Lannie Dobson - Fwd: Press Hotel

From: Deb Andrews
To: Lannie Dobson
Date: 1/13/2015 3:38 PM
Subject: Fwd: Press Hotel
Attachments: 18472 REALES Press Hotel) Portland) Ext Signs) S1 S2 PRES 12-19-2014.pdf

**SIGN NO. 1—DOUBLE FACE INT. ILLUM. PROJECTING WALL ID**  
 SCALE: 3/8"=1'-0"

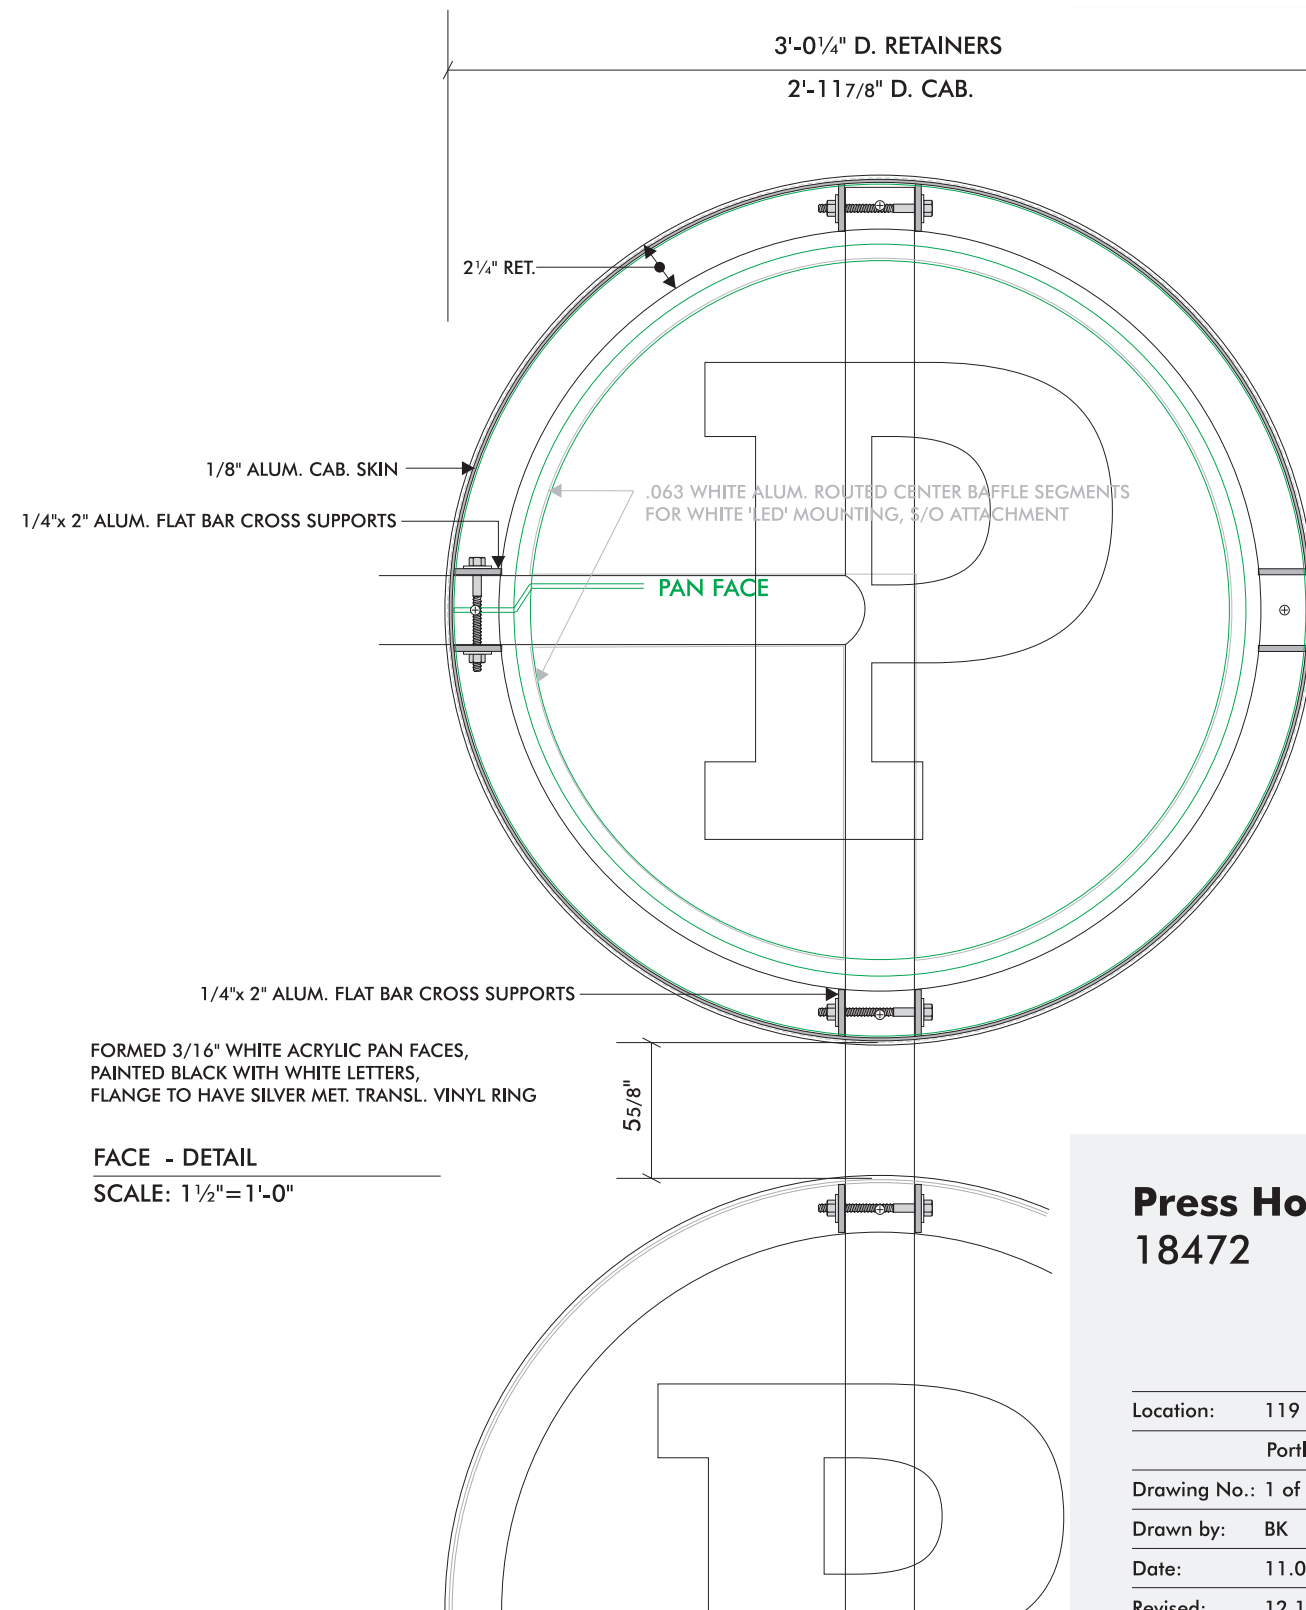
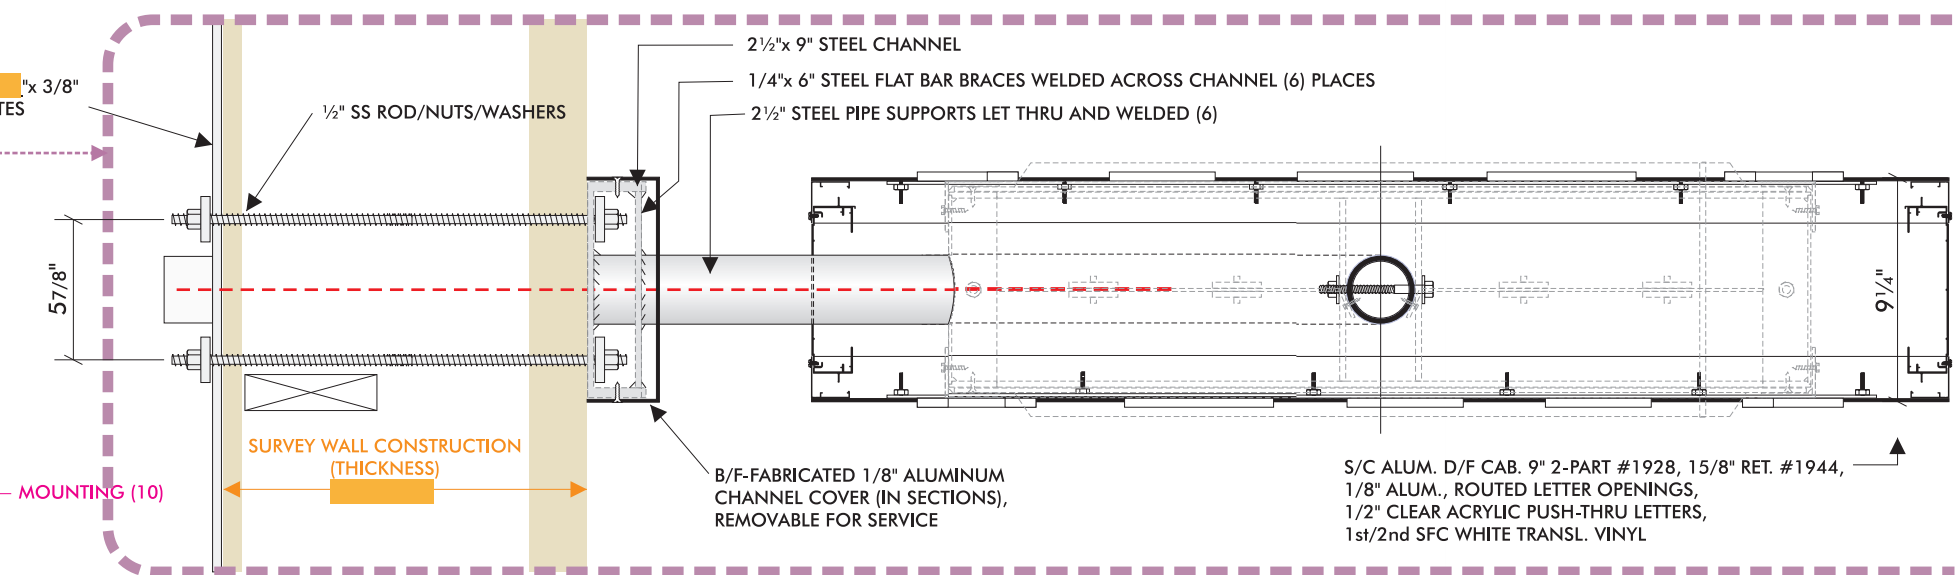
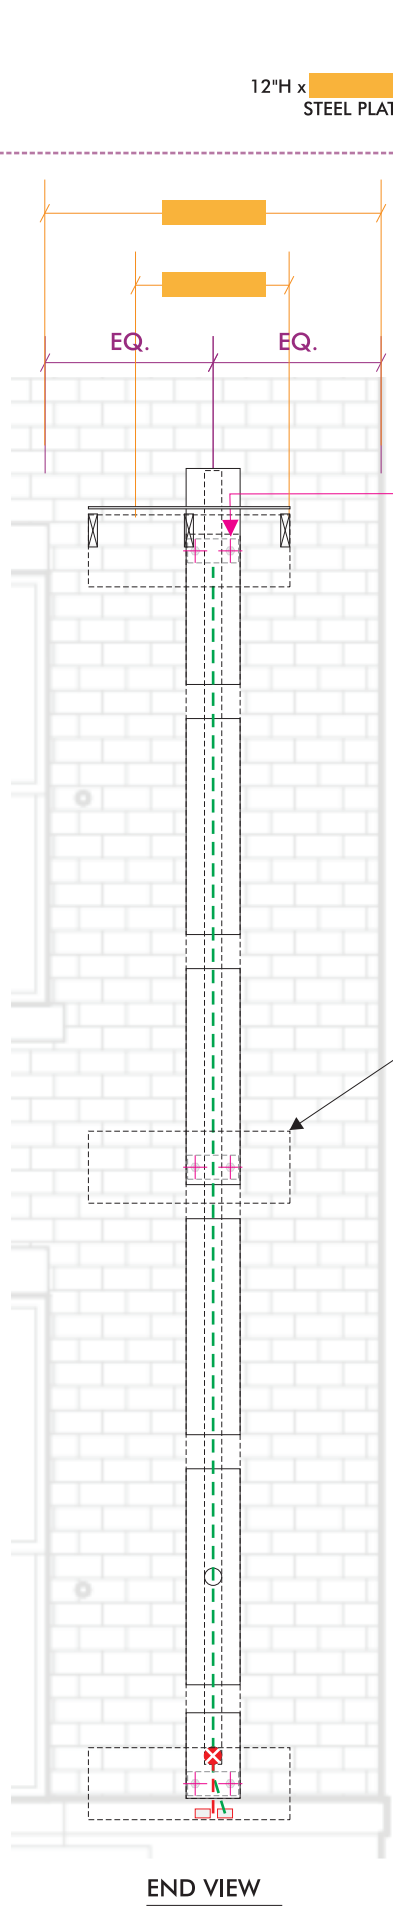
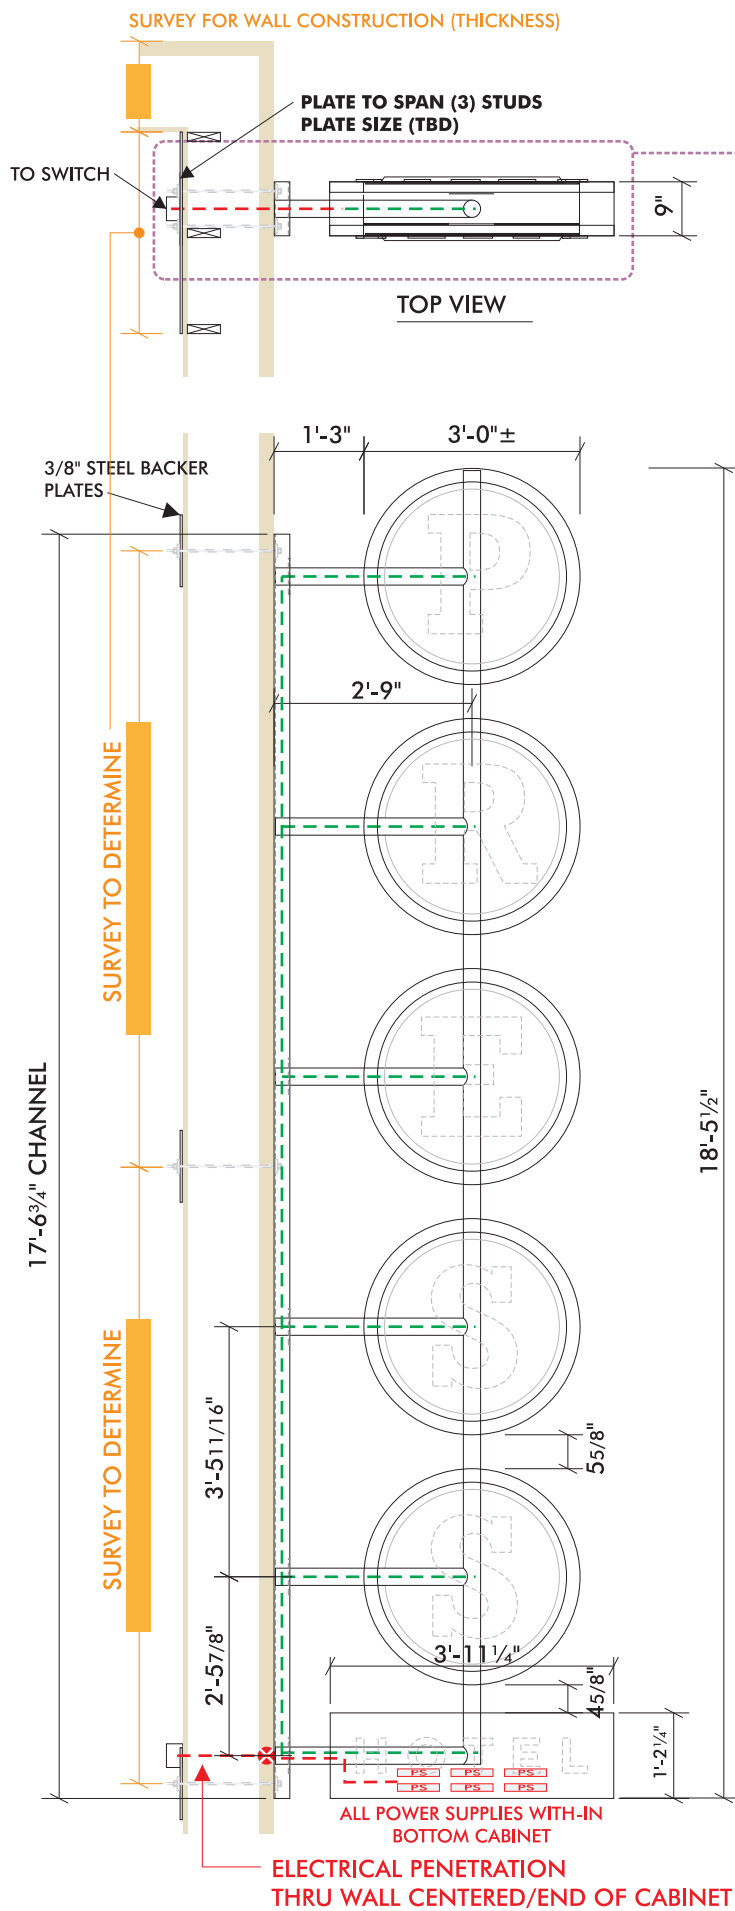
I have attached a revised drawing detailing the changes to the size of the cabinet thickness for the Press Hotel Signs. The wall sign letters are 8" thick. For the double-sided illuminated wall letters, we have scaled them back from 12" to 9". I hope this will suffice because anything less than this may result in the lights actually showing through.
